**Design Review Comment Response 44 Quebec Street  
4-14-2017**

1 NORTH ELEVATION
SCALE: 1/8" = 1'-0"

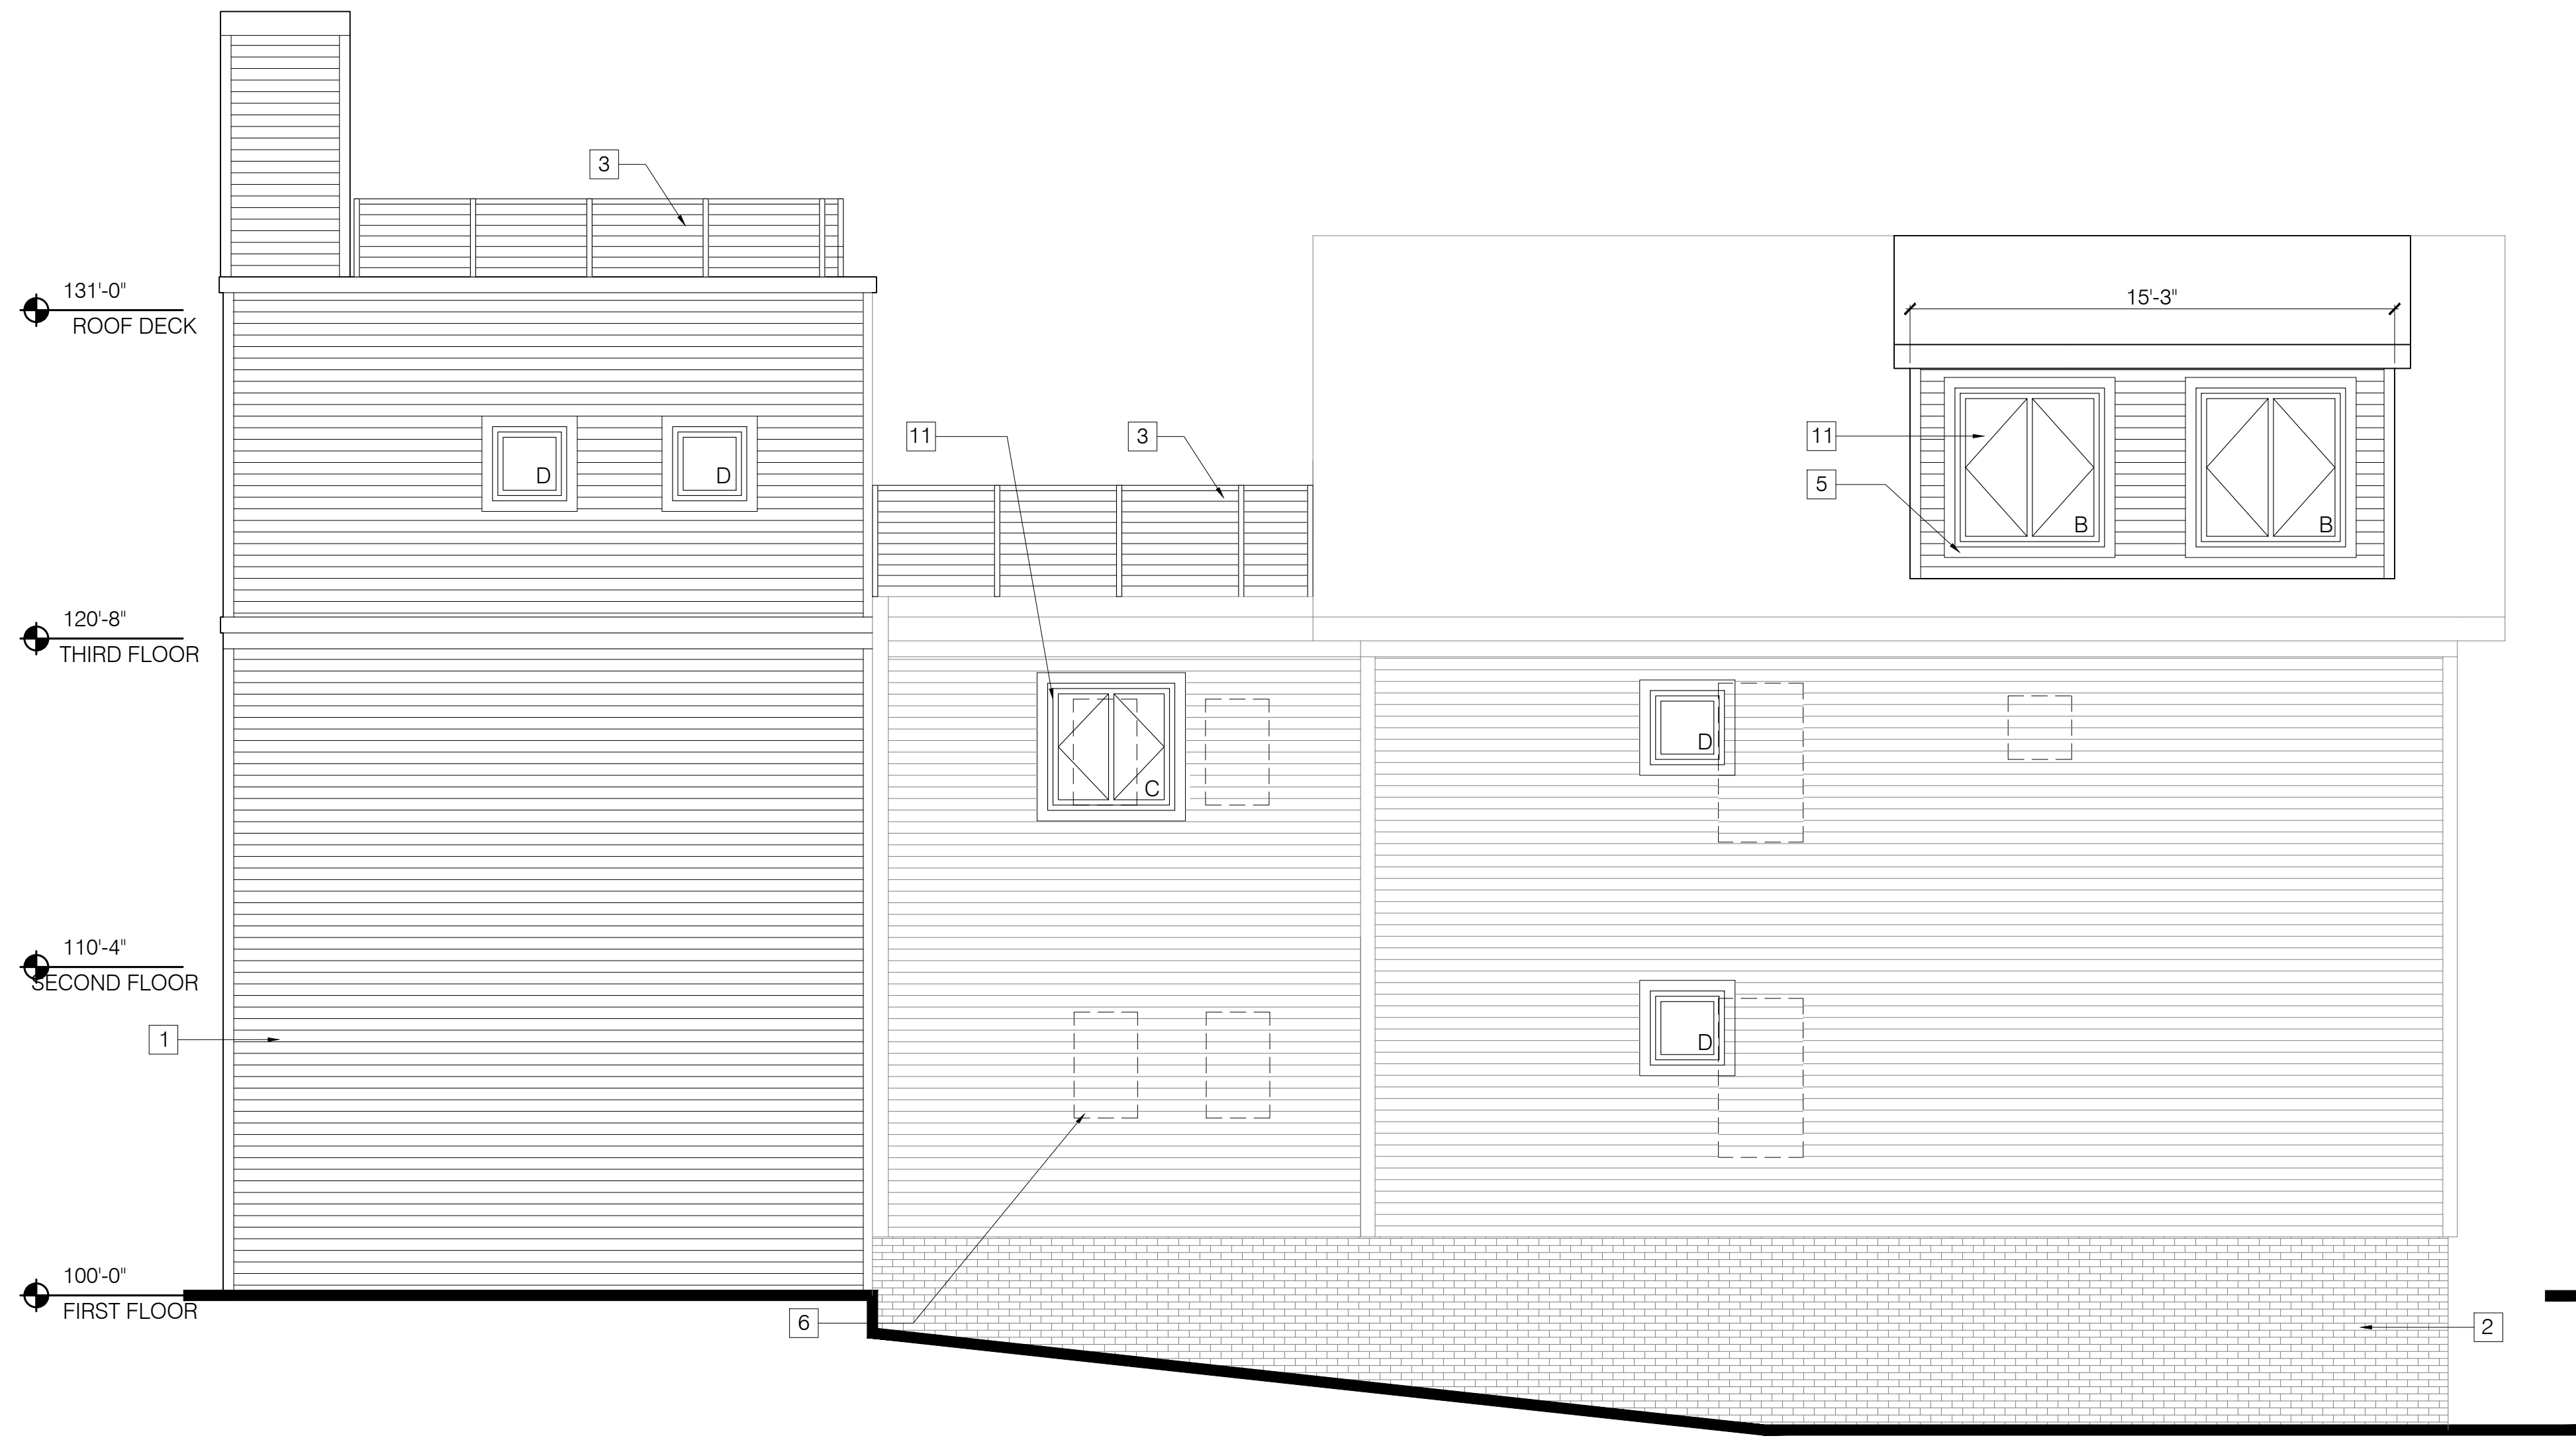
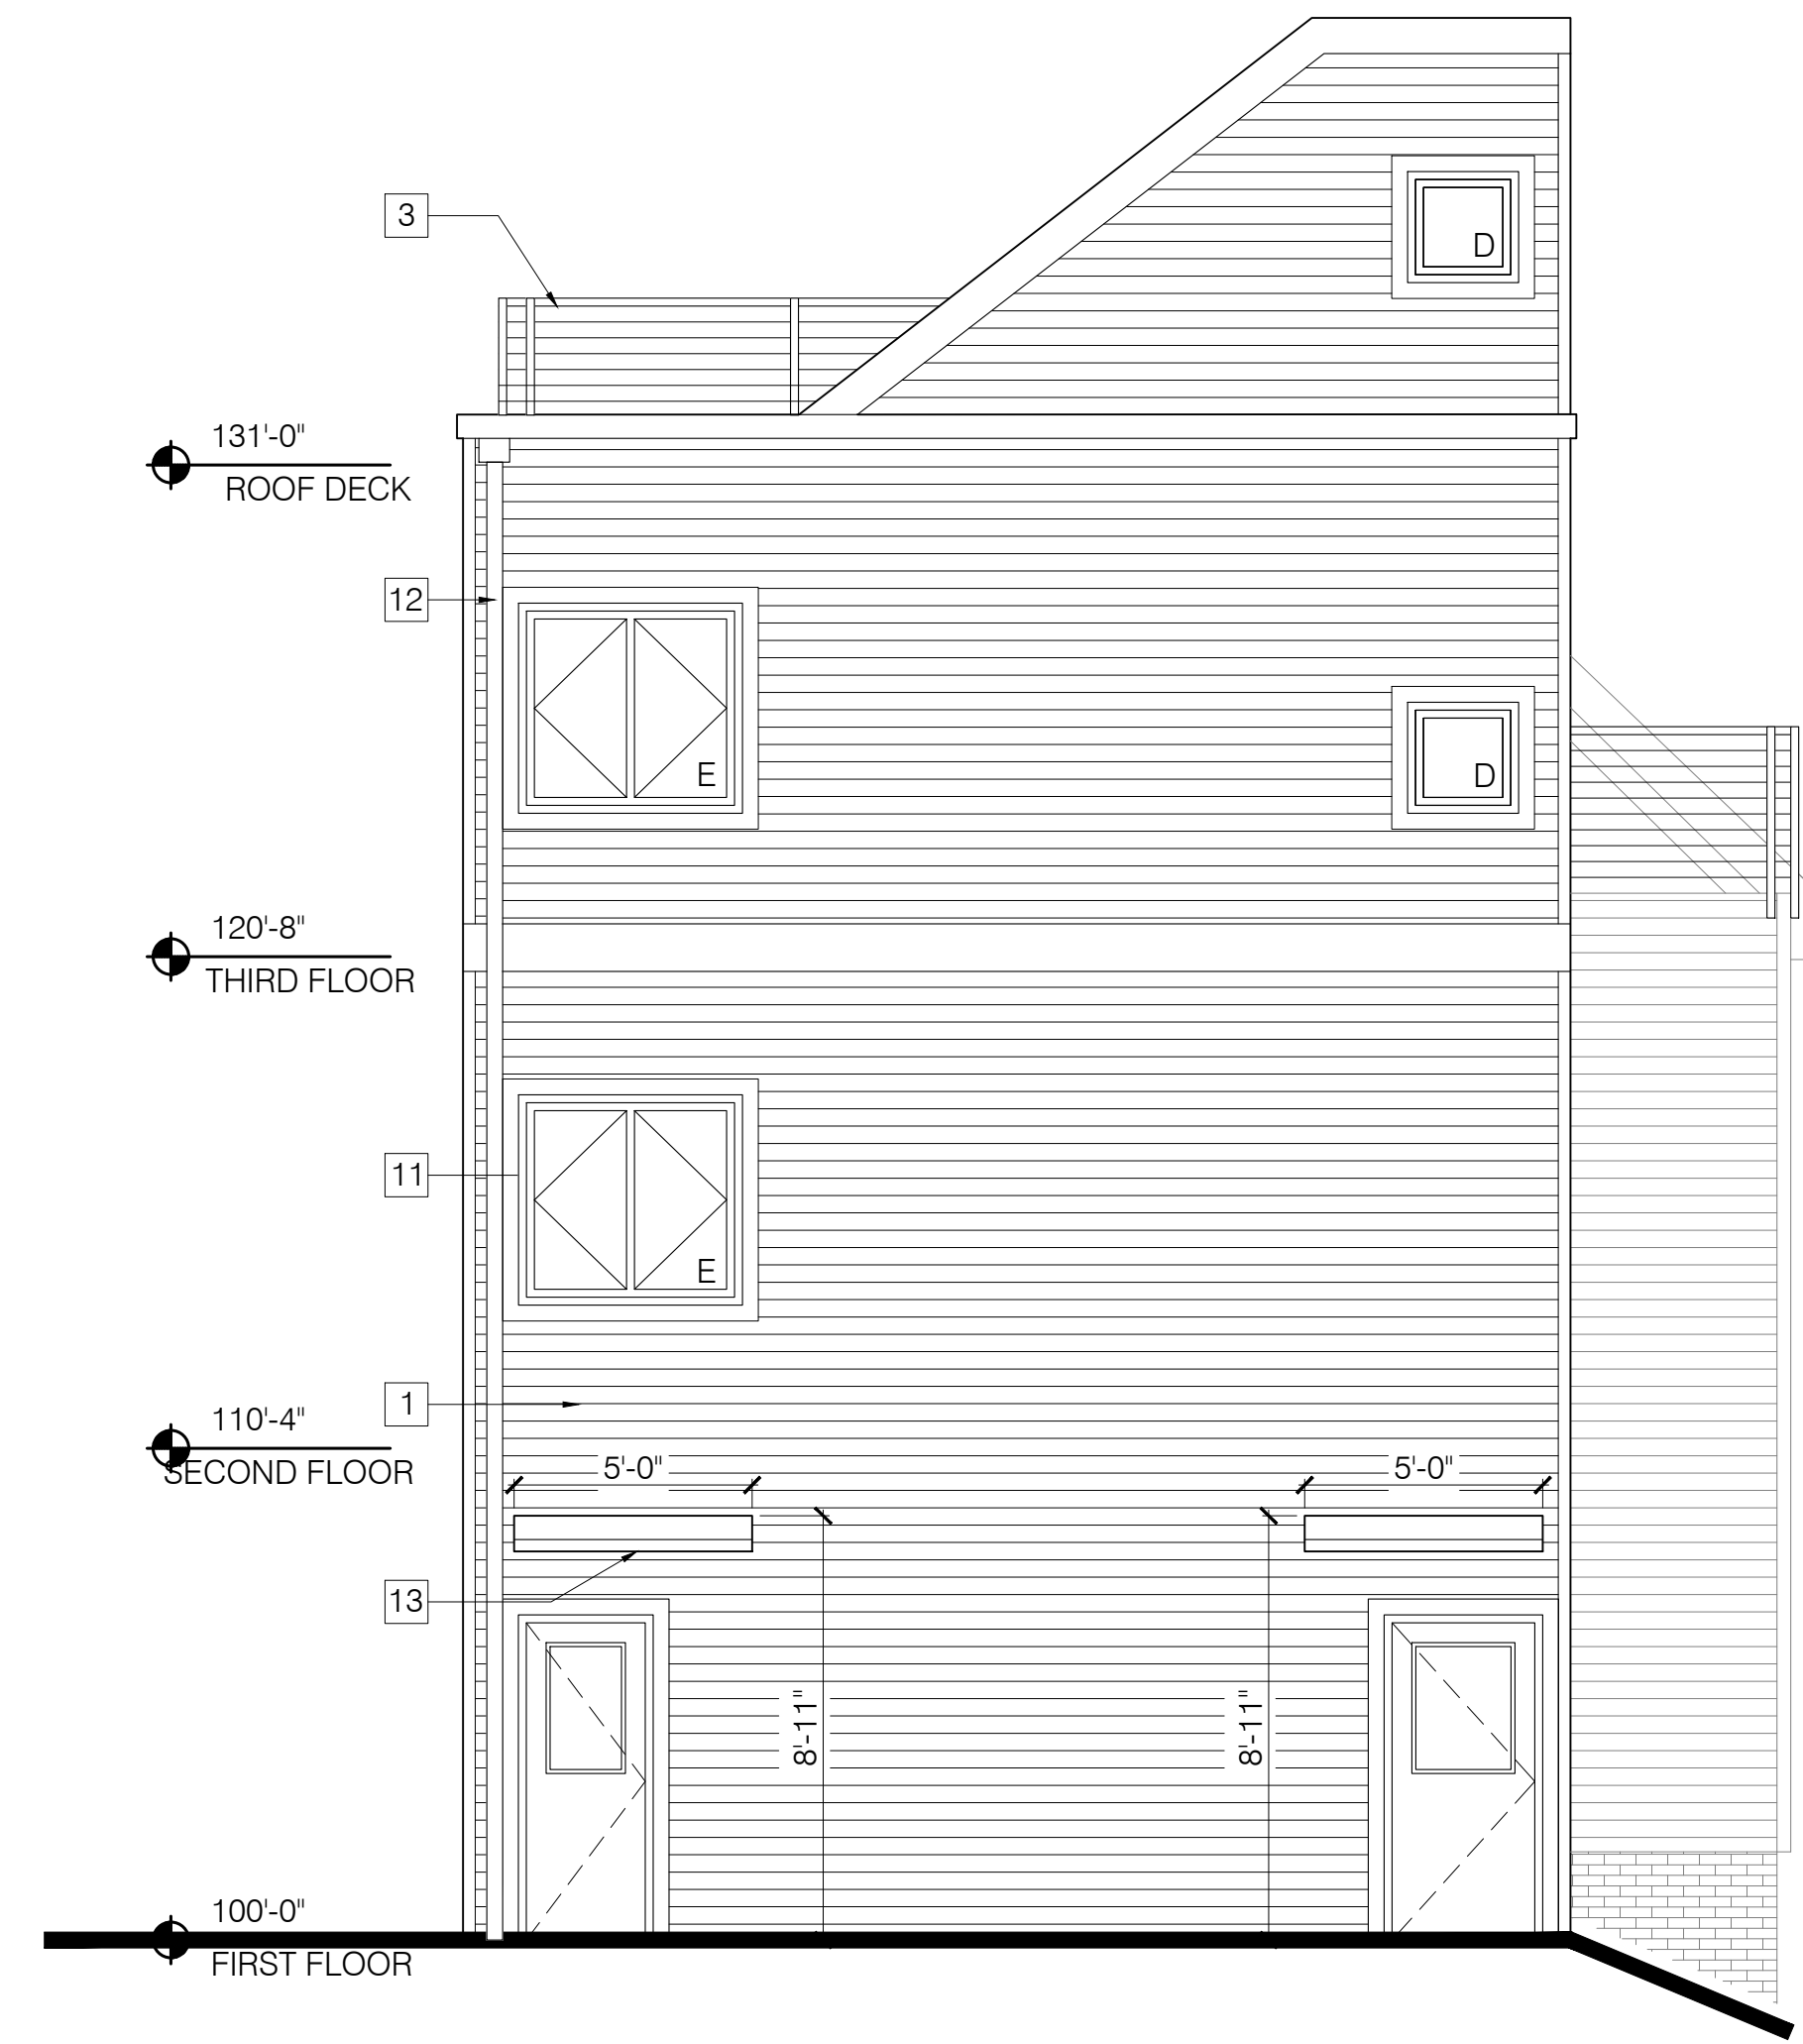
A-2 Windows on the existing building were changed to be more vertical.

B-1 The roof deck railing was moved from being attached to the exterior of the building wall to being placed behind the roof parapet. The roof parapet was also lowered.

B-3 The dormers on both sides of the roof were shortened 2' from the front gable roof. The slope of the dormers were also changed to diminish the amount of façade they showed. The roof deck was moved to be more recessive to the roof line.

D-1 The windows were changed to have a more vertical appearance. The attic window was changed from a square to a more vertical window.

F-1 Around the building a 4" trim was added around all doors and windows on both the existing building and addition.

F-7 We've kept a small profile cornice around the top to try to diminish the prominence of the addition and give more attention to the roof structure of the existing building. As the building sits right on the property line, we are not able to protrude the cornice over the property line. Our client has made it clear that her doesn't want to pursue an easement from the city.
